PLANNING CONSULTATION RESPONSE

Application No	2026/0425
Proposal	Erection of front and side boundary wall (Retrospective).
Address	11 Hardwick Grove, Dodworth, Barnsley, S75 3SS
Date of Consultation Reply	26 th June 2026
Consultee	Highways DC

SITE PLAN
SCALE 1:100

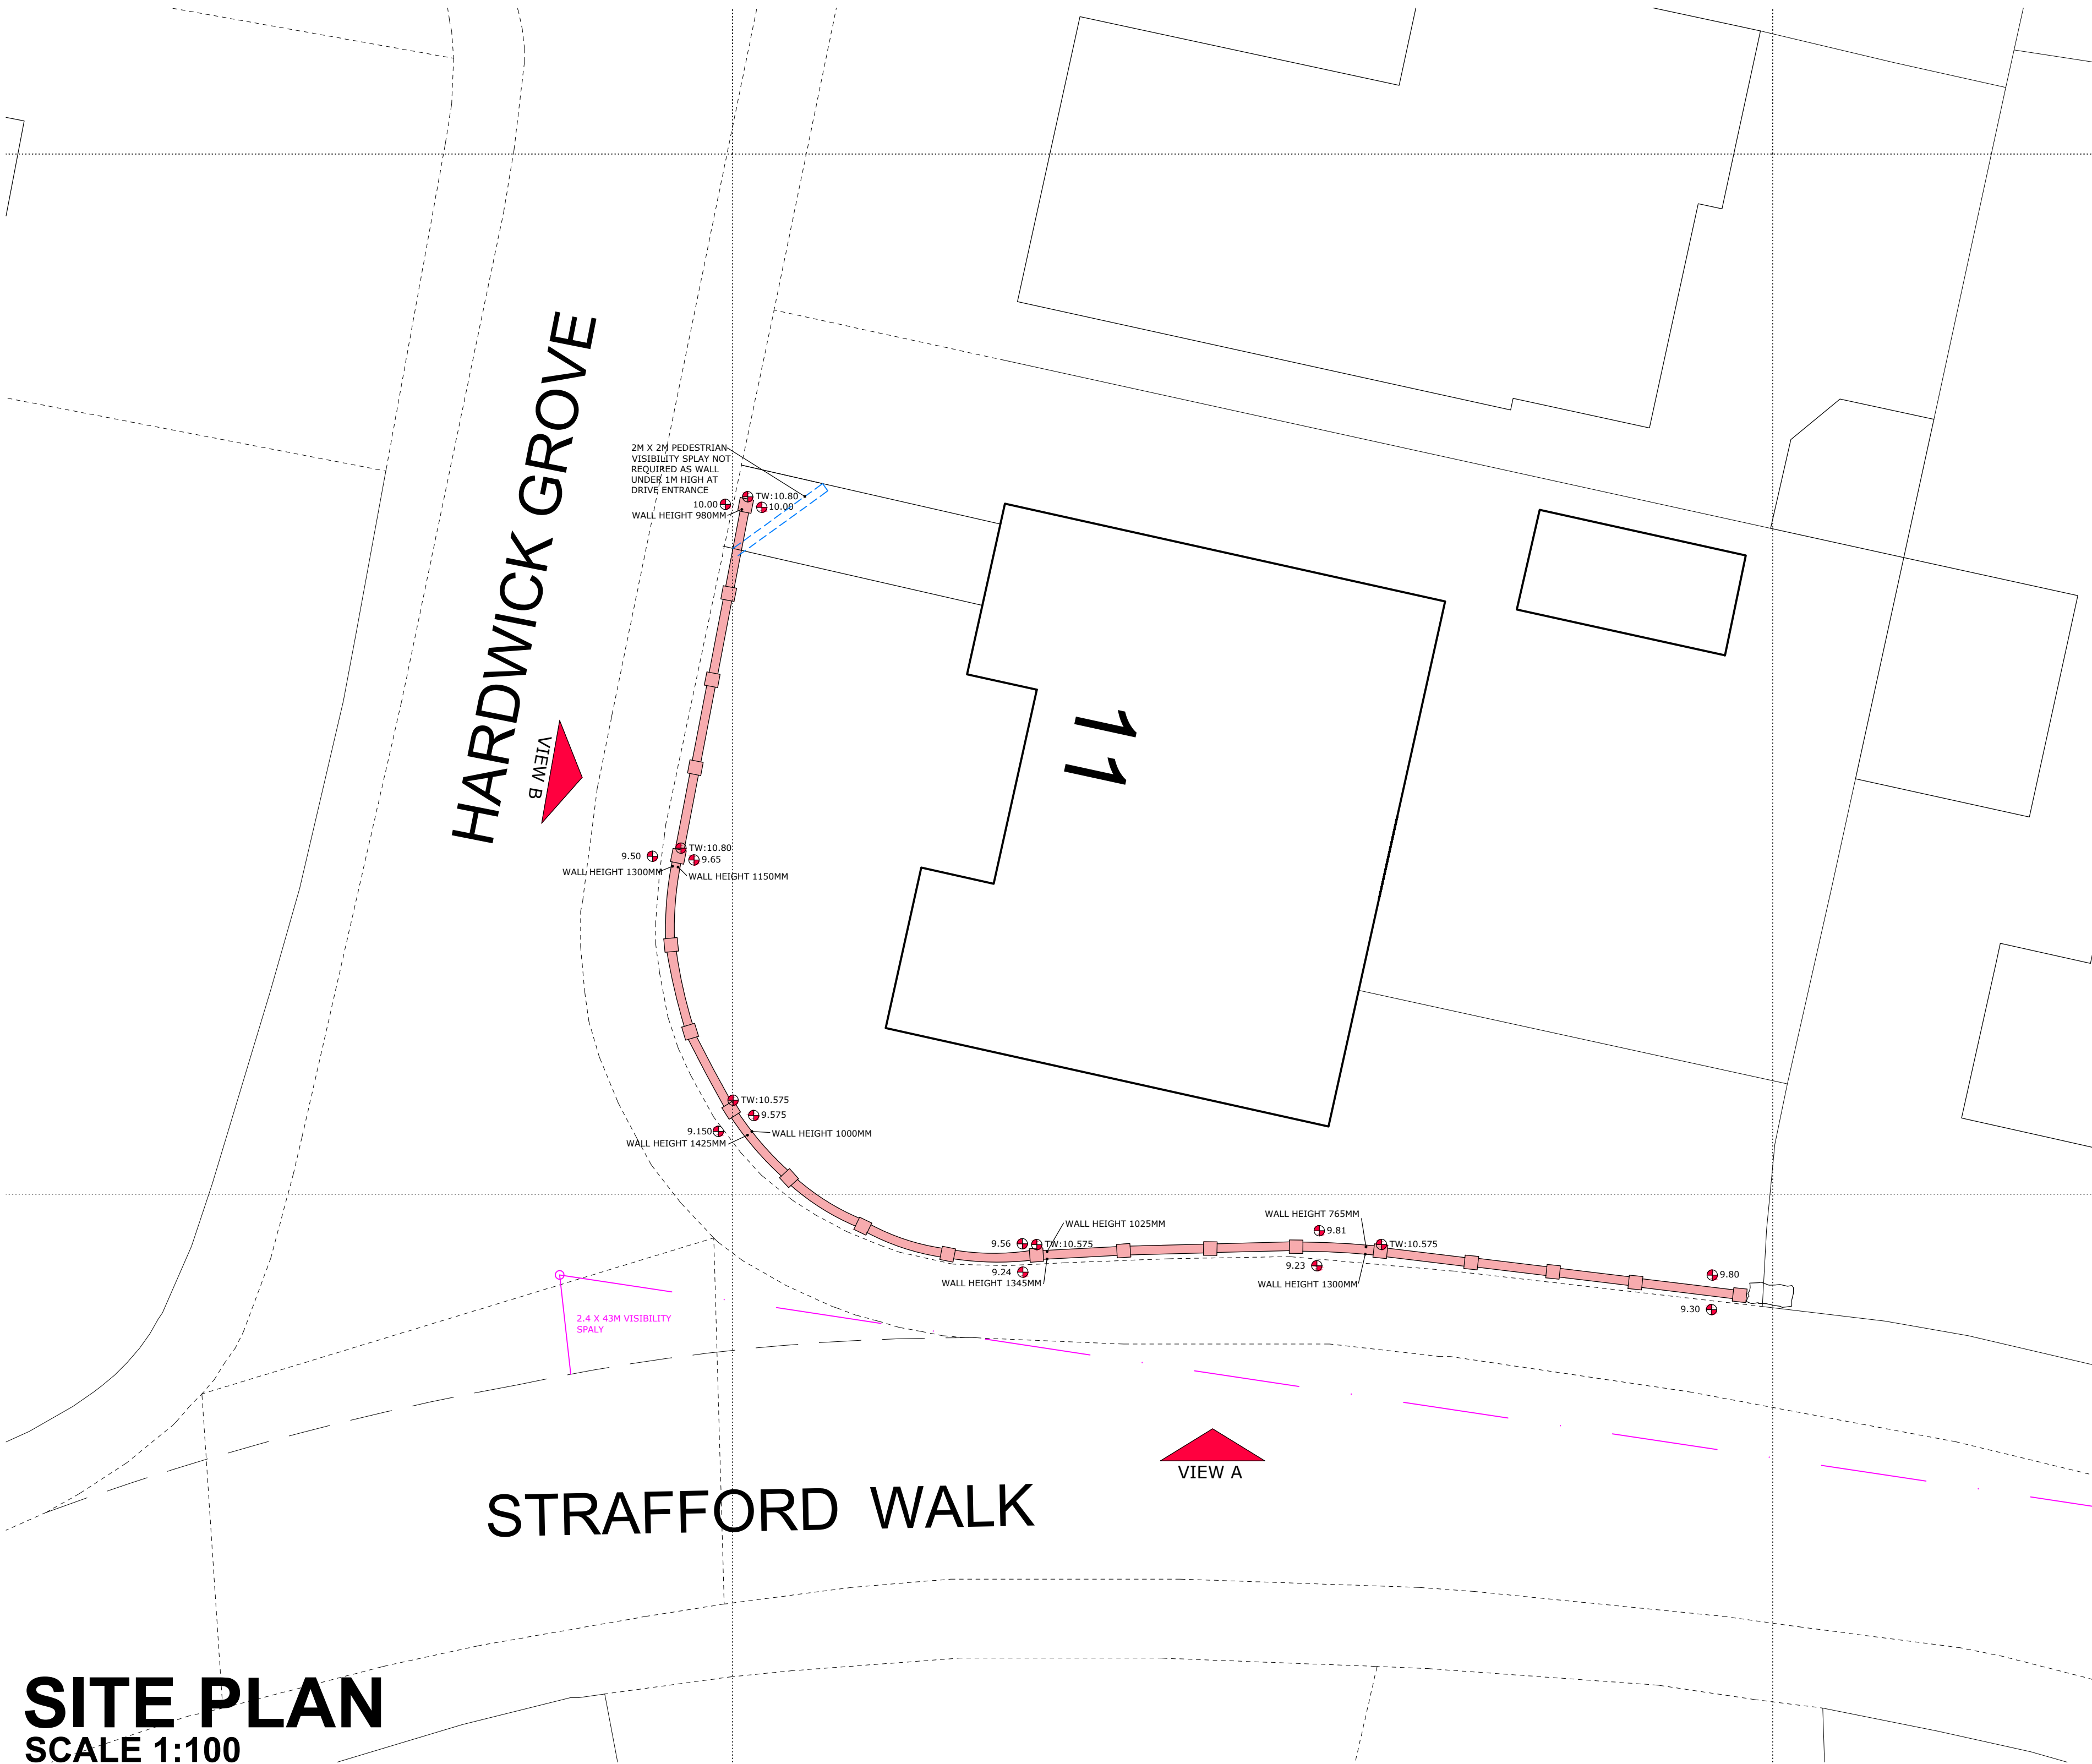
In comparison with the previous application 2026/0102, the submitted details now identify the requirement for the site access to provide 2m x 2m pedestrian visibility splays. However, the site layout plan incorrectly states that the visibility splays are not required because the boundary wall is below 1m in height (980mm) at the driveway entrance. Pedestrian visibility splays are required at a vehicular access onto the public highway regardless of wall height and anything within the 2m x 2m splays cannot exceed 600mm in height. The boundary wall would not necessarily need to be splayed into the site as indicated on the plan, the splays are ordinarily achieved by ensuring that any portion of the boundary wall that falls within the 2m x 2m splays does not exceed 600mm in height.

Notwithstanding the above, now that the position of the wall has been accurately shown on the site layout plan, it is evident that the wall does not actually impede the required 2m x 2m pedestrian visibility splays as can be seen in the image below which is an extract of the site layout plan with the visibility splays drawn on.

The vehicular access shall provide pedestrian visibility splays of 2m x 2m to the back edge of the footway. Nothing shall be erected, retained, planted and/or allowed to grow at or above a height of 0.6m to the rear of the footway which would obstruct the visibility splays. The visibility splays shall be maintained free of obstruction at all times thereafter for the lifetime of the development.
